IP Ref 2004 6952

#### **IP Ref 2004 6952 Charlwood Society's Response to the above**

The Charlwood Society has noted the Examining Authorities Challenge to the applicant in ExQ1 Reference HE 1.4 (Page 65) requesting further justification of the statement that ground noise effect would be negligible.

DRAWING TITLE  
**Designated Heritage Assets within 3 km of the Project Site Boundary**

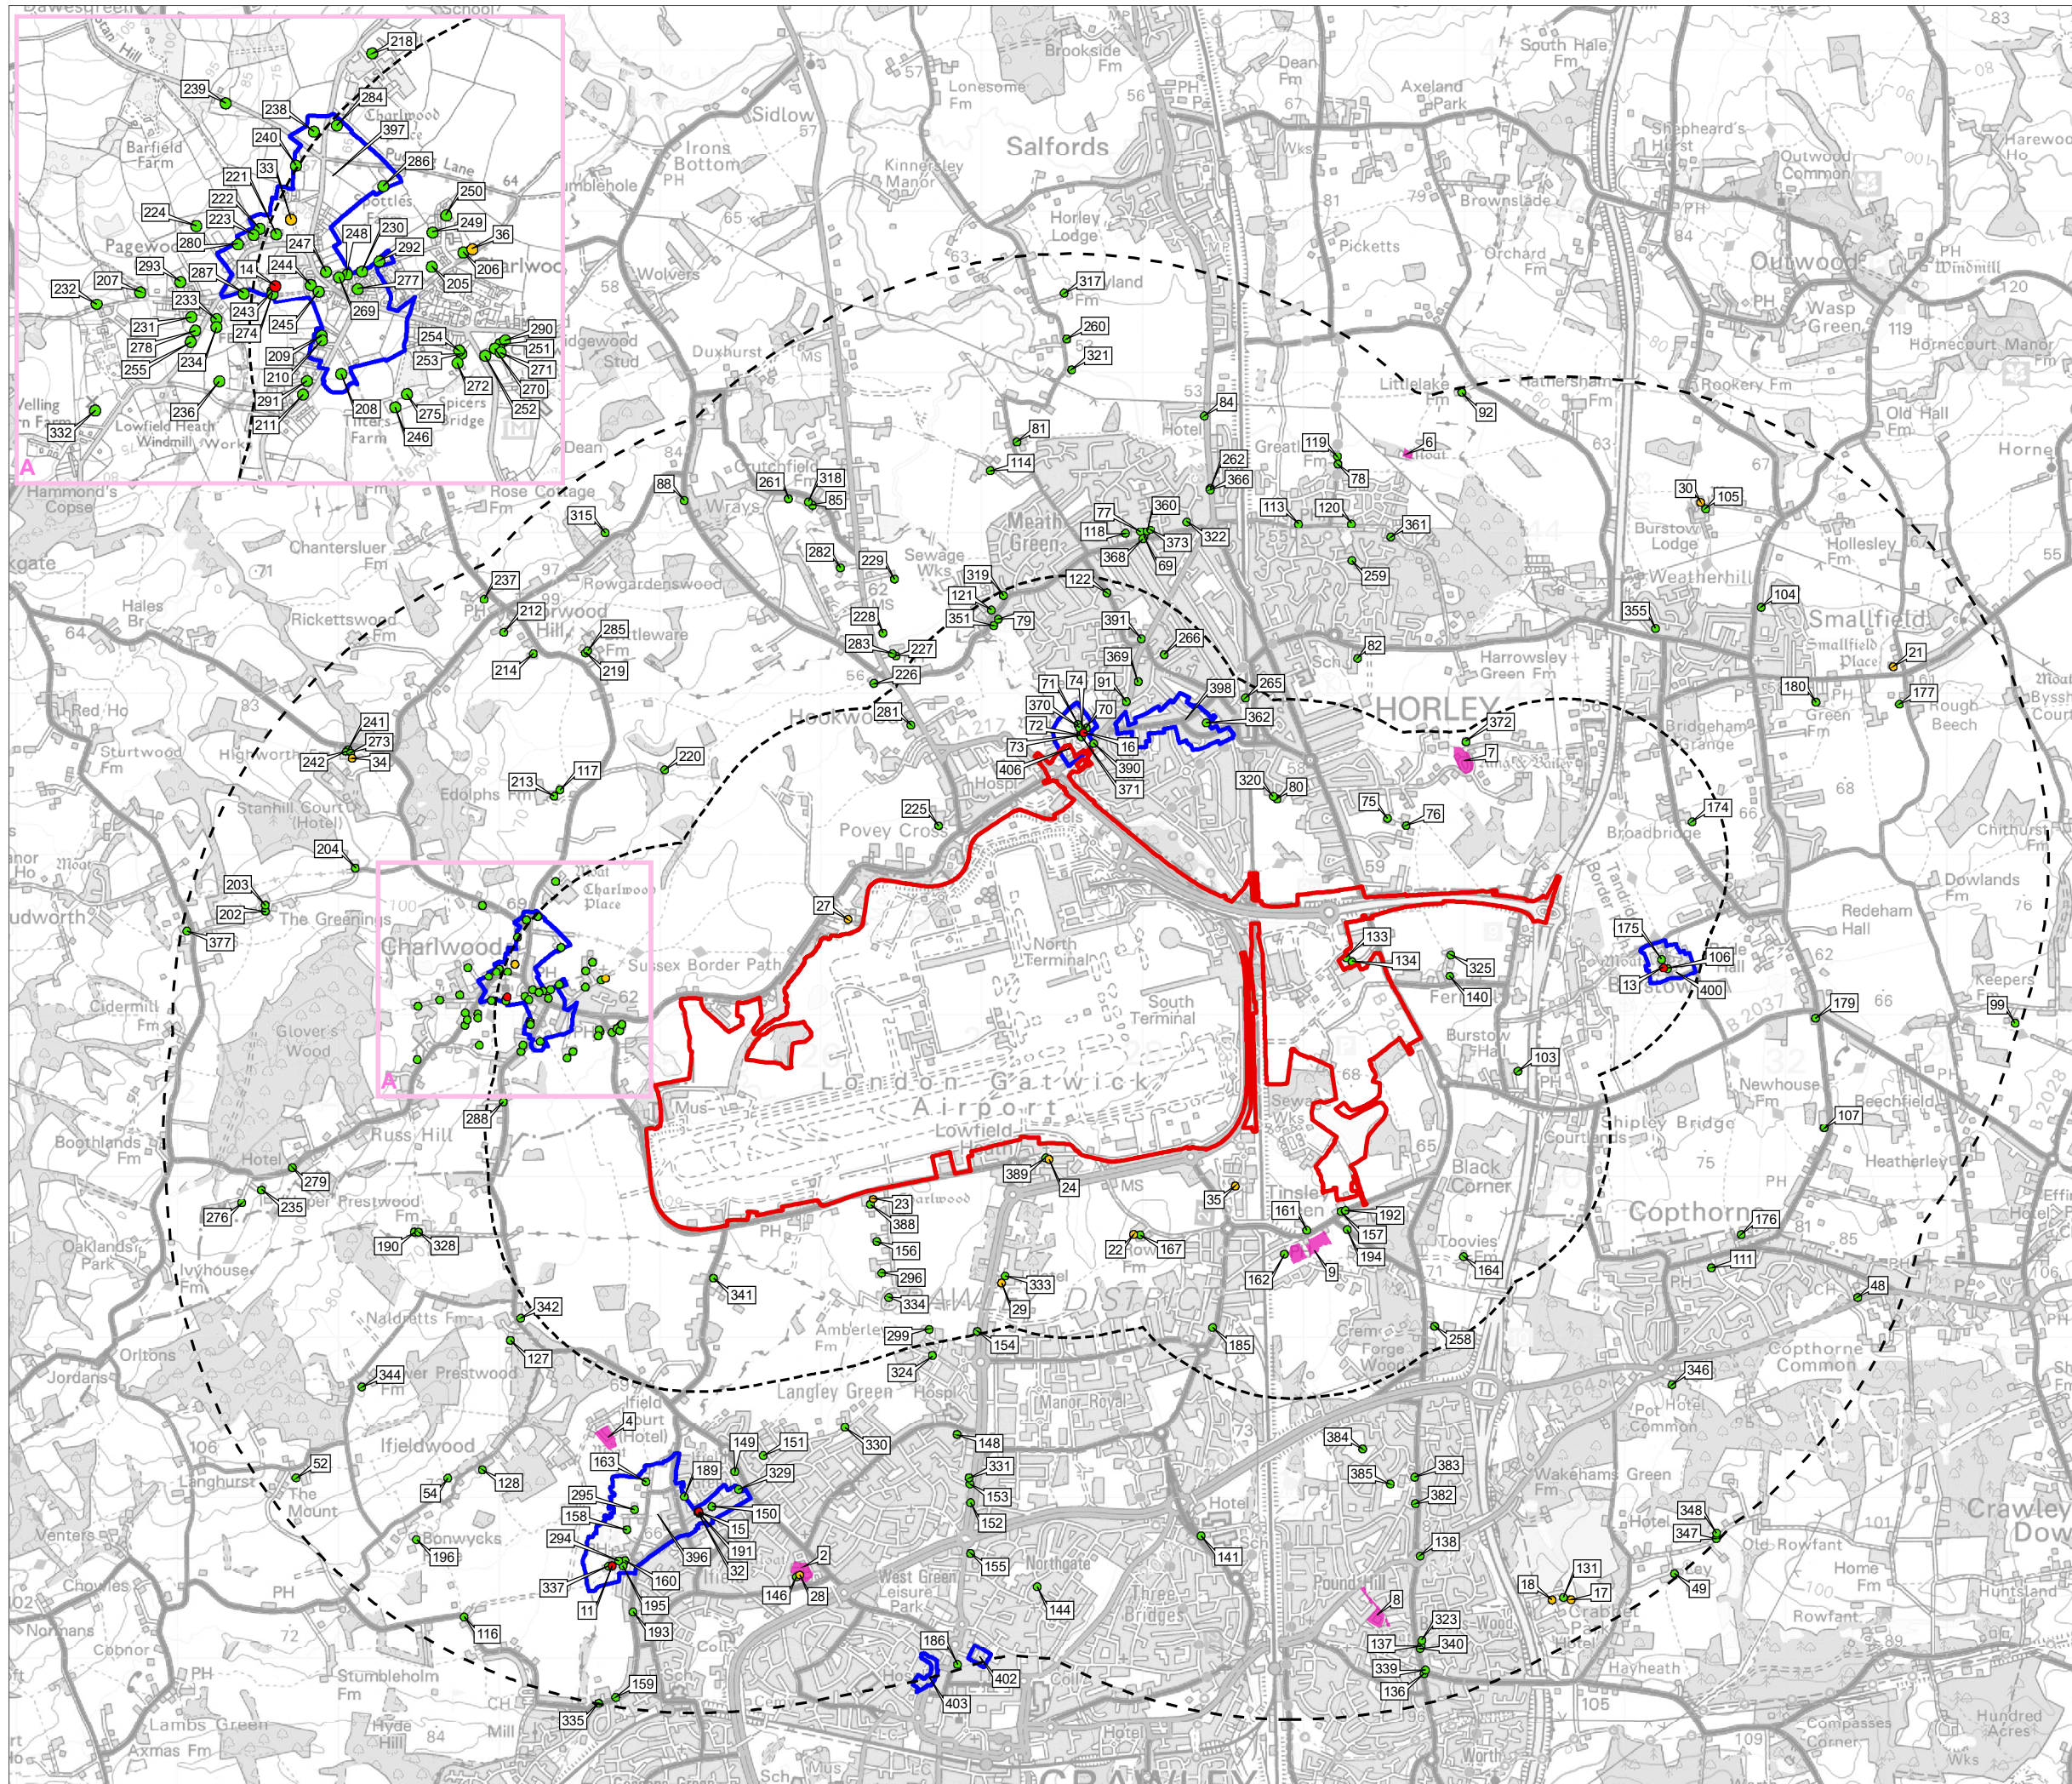
Are such assets considered to be more susceptible to noise from aircraft given that they may be considered to be places where people are likely to take quiet reflection? Provide further justification for your view that effects from ground noise on these heritage assets would be negligible [APP-032].

We know that this is not to be the case for both buildings and in fact for the whole of Charlwood conservation area. Events at both locations (St Nicholas' Church and The Providence Chapel) are impacted by individual noise occurrences. Thus, the use of 16hr Leq measurements does not reflect the true impacts. The church has regular services of worship together with weddings and funerals and is often used by visitors as a location for quiet meditation. The chapel is used regularly for school services, assemblies and also used for meditation and yoga classes. Thus, both sites can be seen to be affected by individual noise events when they are in use.

the Grade I listed Church of St Nicholas (**ES Figure 7.6.2** (Doc Ref. 5.2), Site 14), along with The Manor House (Site 33) and the Providence Chapel (Site 36), both of which are listed at Grade II\*. Both the listed Church of St Nicholas (Site 14) and the Providence Chapel (Site 36) are classed as noise- sensitive heritage assets using the criteria established for the assessment of impacts arising from air noise change (Temple Group and Cotswold Archaeology, 2014). The magnitude of impact on each of the three heritage assets of high sensitivity or value at Charlwood has been assessed as negligible and long-term. The consequent significance of effect in respect of these three heritage assets would be **minor adverse**, which is not significant in terms of the EIA regulations.

- 131.** The Charlwood Conservation Area is a heritage asset of medium sensitivity or value, as are the 33 Grade II listed buildings within and adjacent to the Conservation Area (and within the defined study area – see **ES Figure 7.6.2** (Doc Ref. 5.2)). As described above, the magnitude of impact on each of these heritage assets has been assessed as negligible and long-term, with the consequent significance of effect in each case being assessed as **negligible adverse**. This is not significant in terms of the EIA Regulations.
